MEMORANDUM

DATE: February 12, 2020

SUBJECT: SF-19-009– Retreat at Timber Ridge Filing 1  
Second Submittal

DUAL STORM CULVERT ASPEN VALLEY ROAD CROSSING 24\"/>

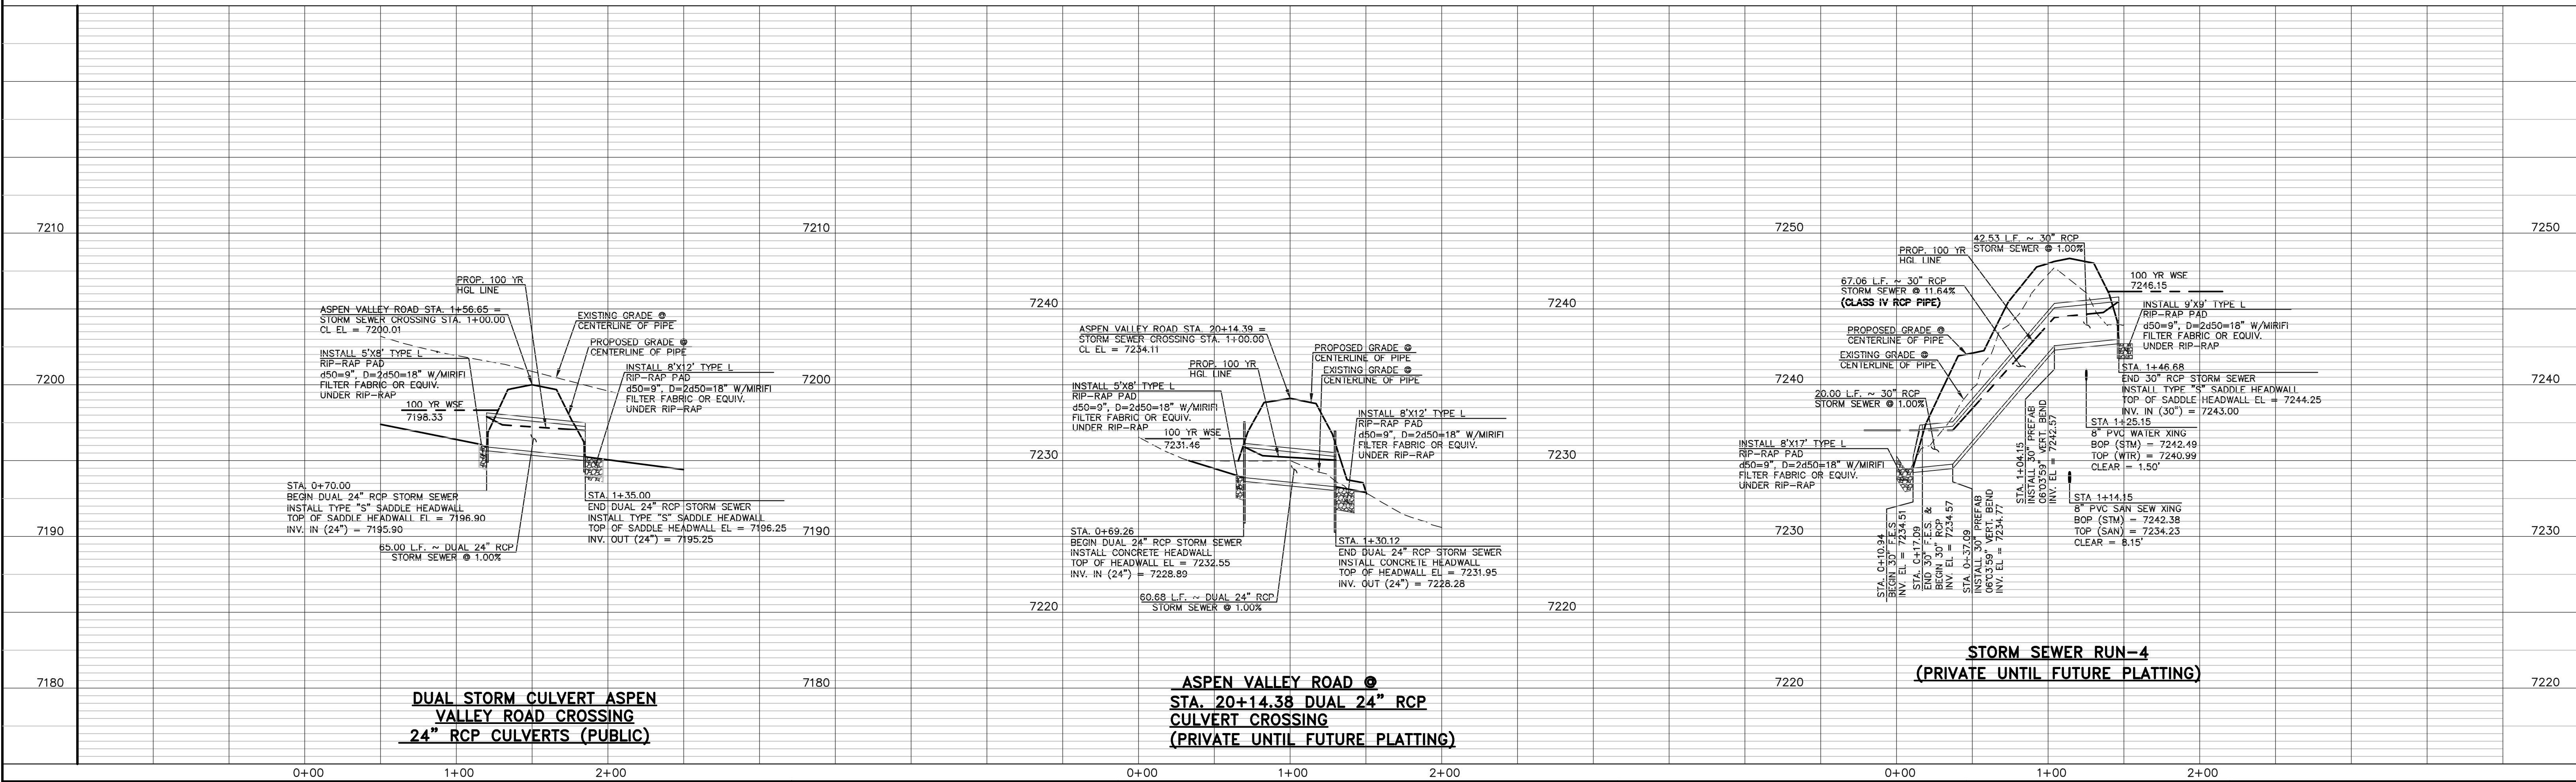
17. **Utility Plans:**
  - a. Provide a copy of the necessary offsite easement(s) when available. **Noted**
  - b. Ensure that the proposed Poco Road culverts are labeled properly. **Revised**
